From: Michael Coyne <coyne@archetypepa.com>
To: Jeanie Bourke <JMB@portlandmaine.gov>
Date: 11/3/2015 1:59 PM
Subject: RE: Permit No. 201502013 - 135 Walton Street
Attachments: A3 Scope of Work.pdf

From: Jeanie Bourke [mailto:JMB@portlandmaine.gov]
Sent: Tuesday, November 03, 2015 10:24 AM
To: Michael Coyne
Subject: Re: Permit No. 201502013 - 135 Walton Street

I know Bill Hopkins met with you yesterday about the project at 135 Walton Street. Attached is our amended drawing to the permit we received last week (permit no. 201502013) referencing the construction type of the new walls for the renovation, based on yesterday's meeting. If you need anything else let me know.

4 WALL TYPE
SCALE: 1-1/2"=1'-0"

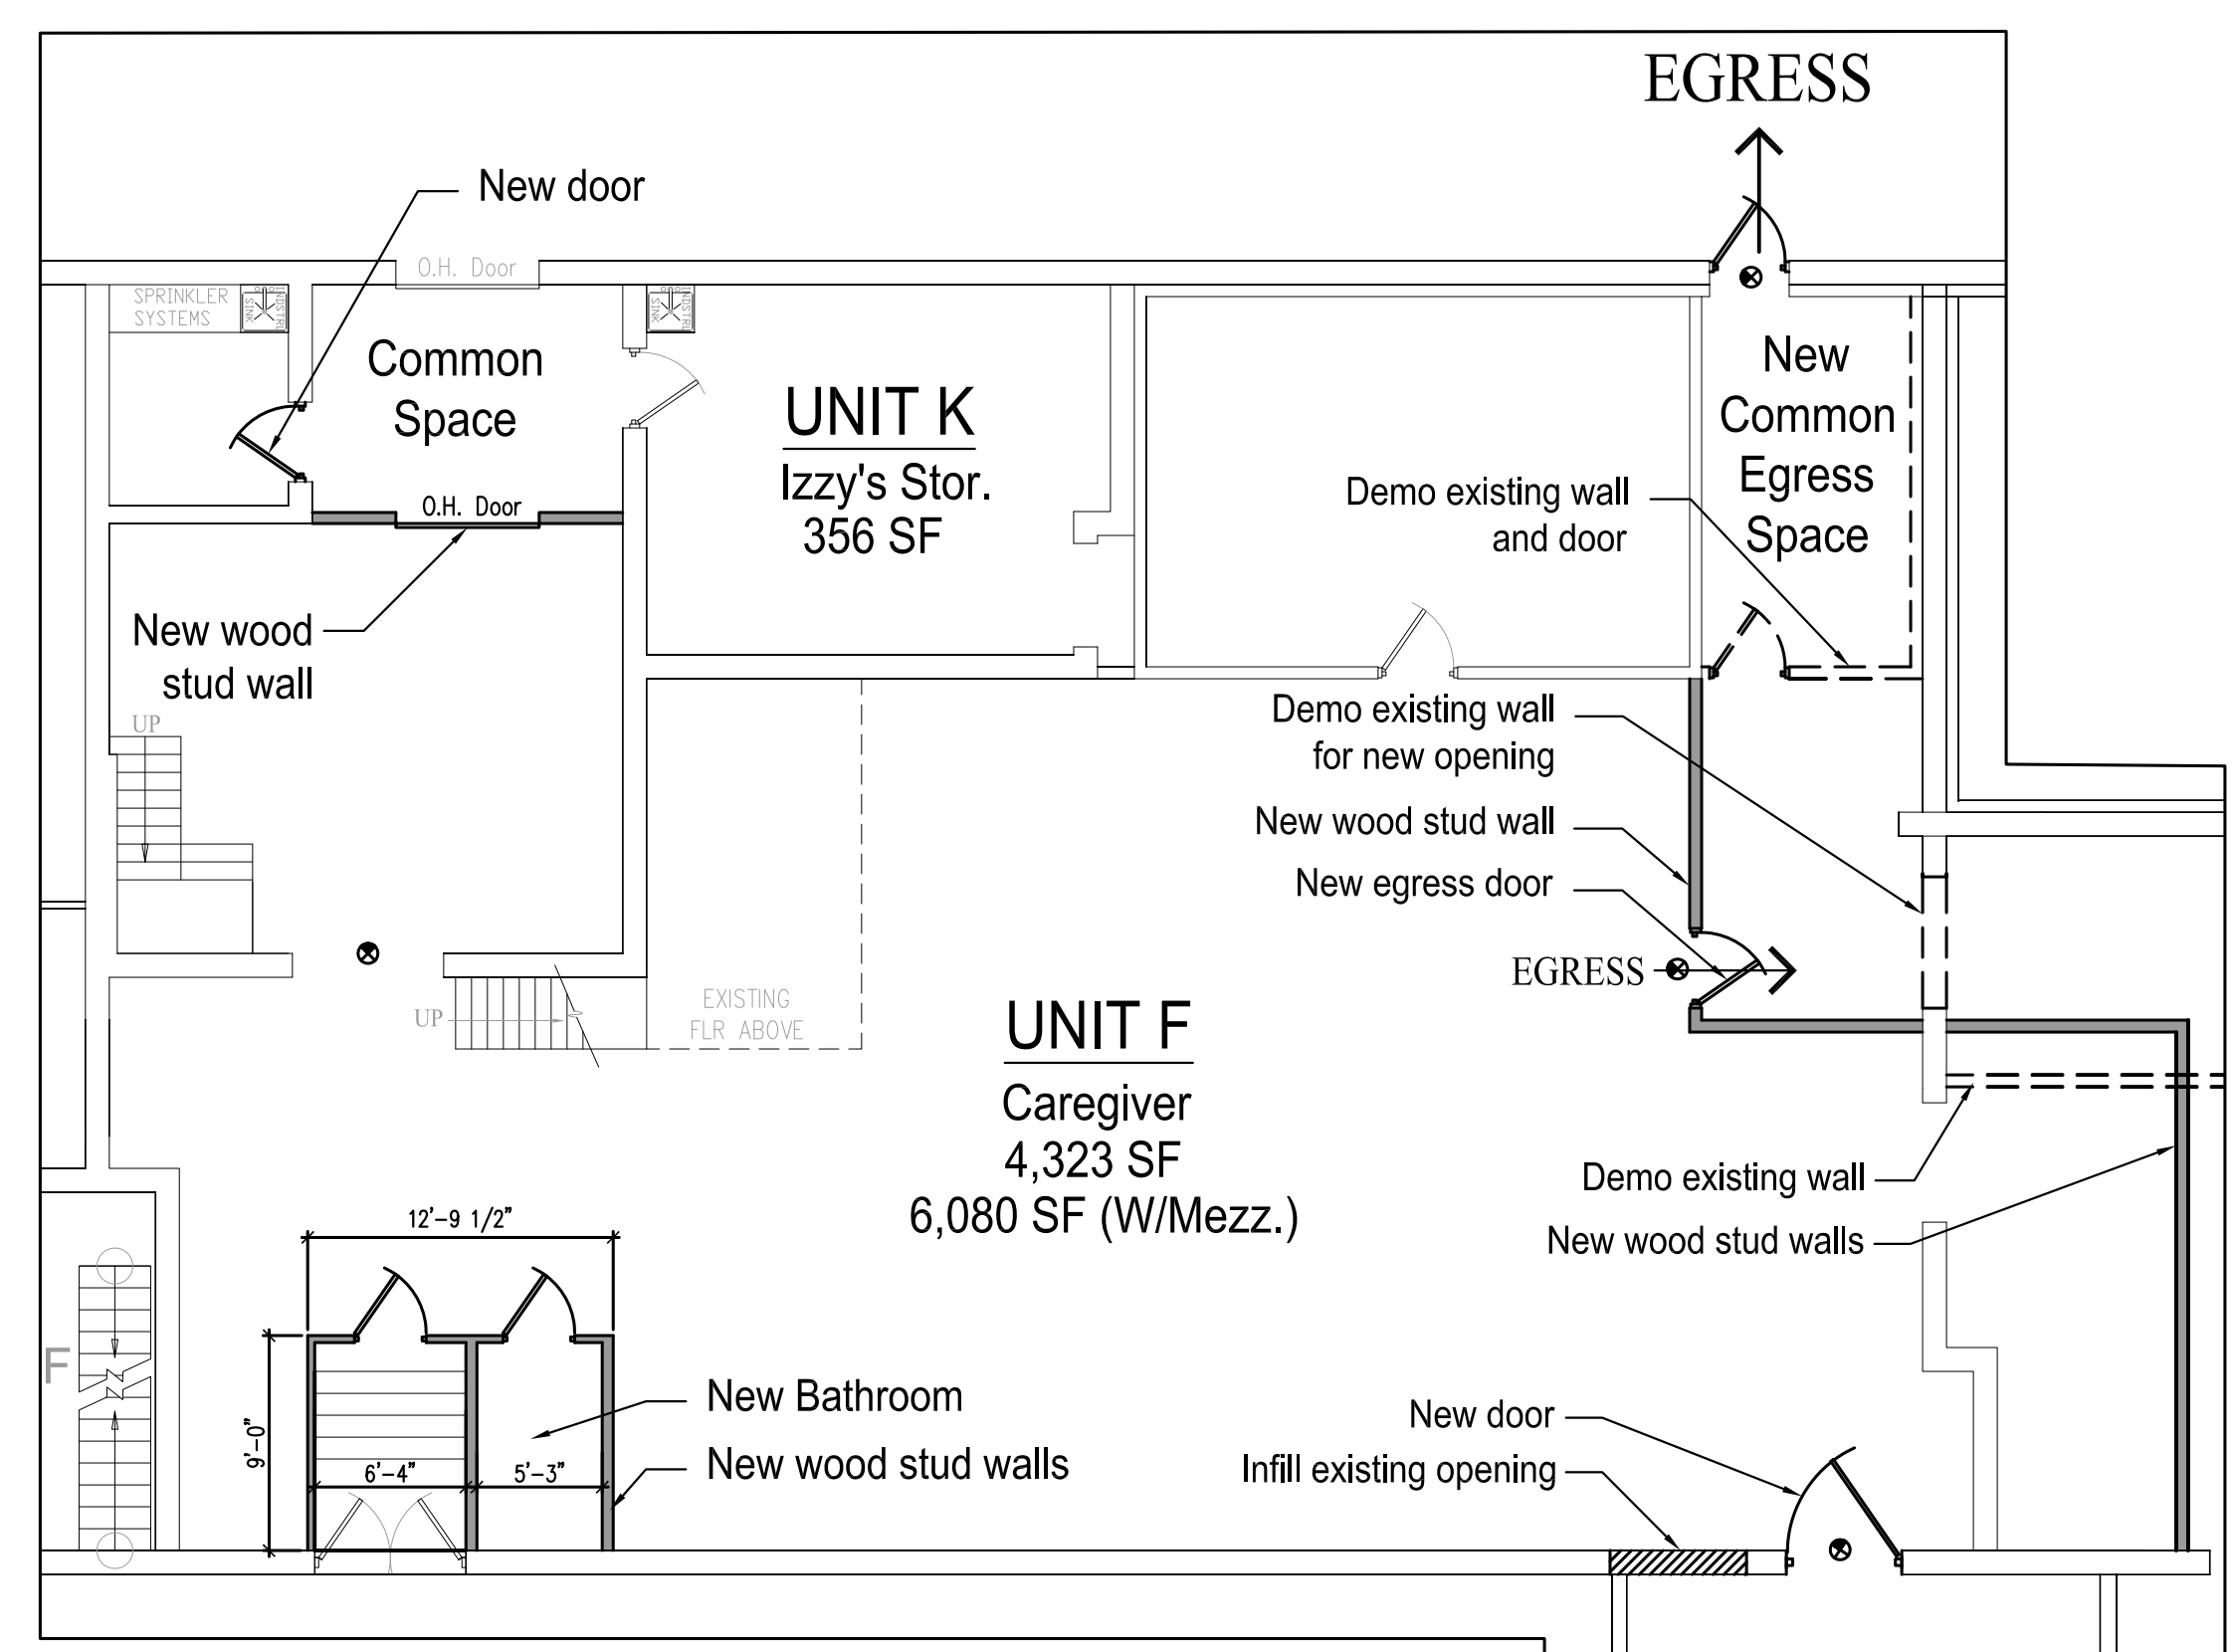
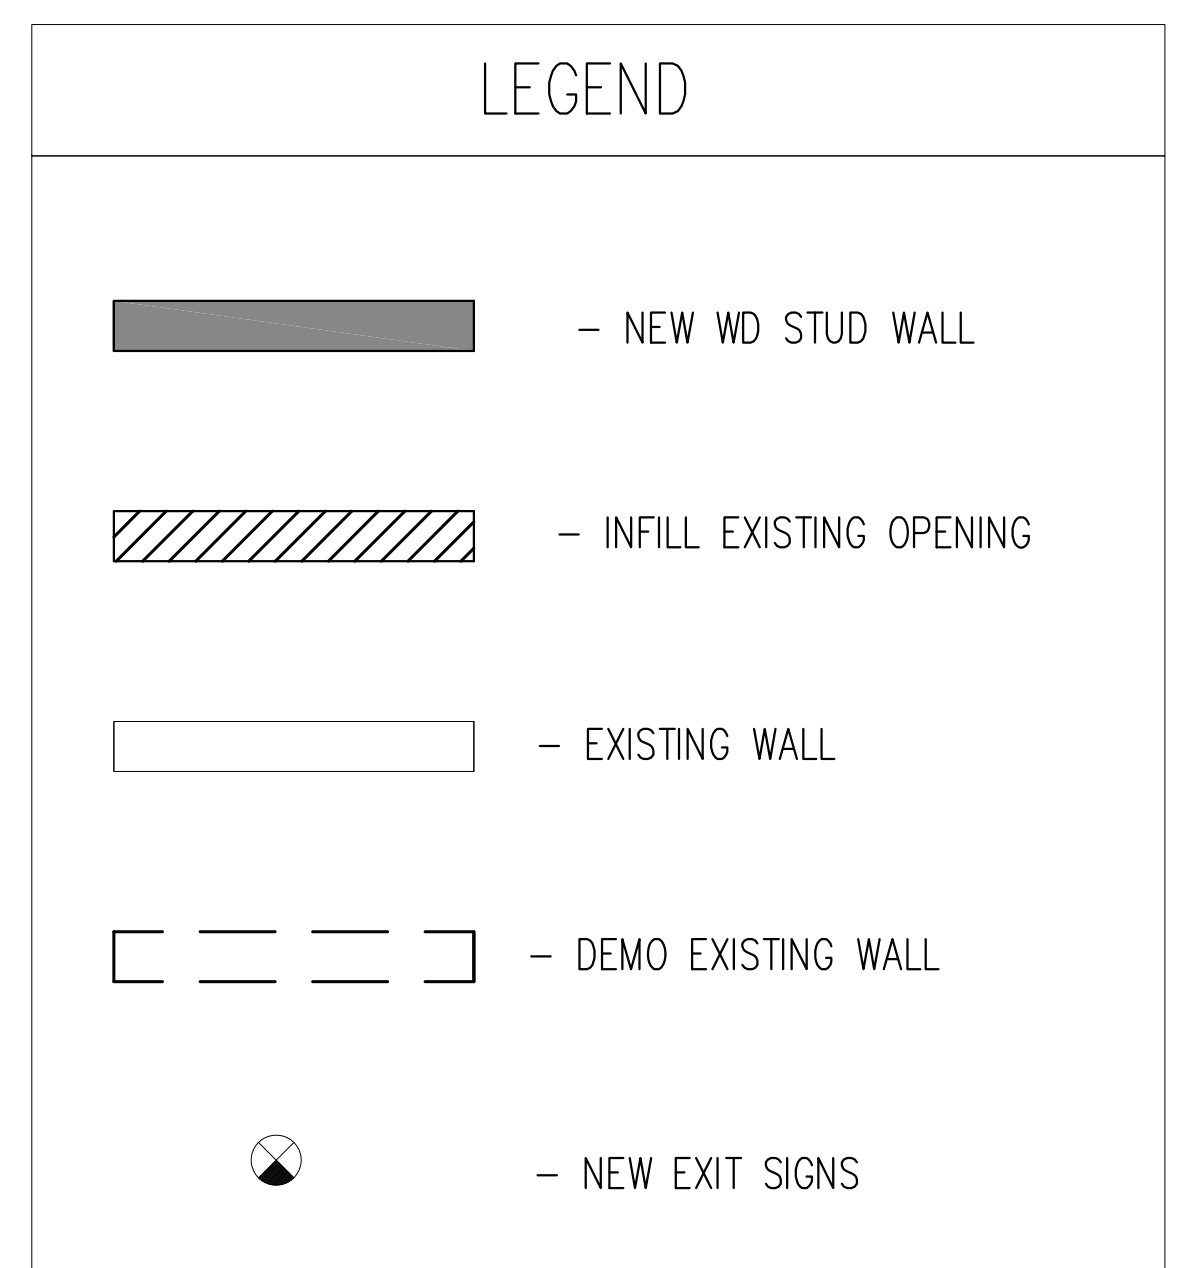
2. For the W1 wall type specify the head of wall detail and if this is a required fire resistive wall with joint.

1. Change this pdf file name to be consistent with the original, ie. A3 Scope of Work.
2. For the W1 wall type specify the head of wall detail and if this is a required fire resistive wall with joint.

Per the discussion had about the project, *all* new wood walls are to be one hour rated, in lieu of a non-rated, non-combustible system. There is no rating required, but in order to resolve the issue of the wall types, we are providing a 1-hour rated system. (also now stated on the drawings)
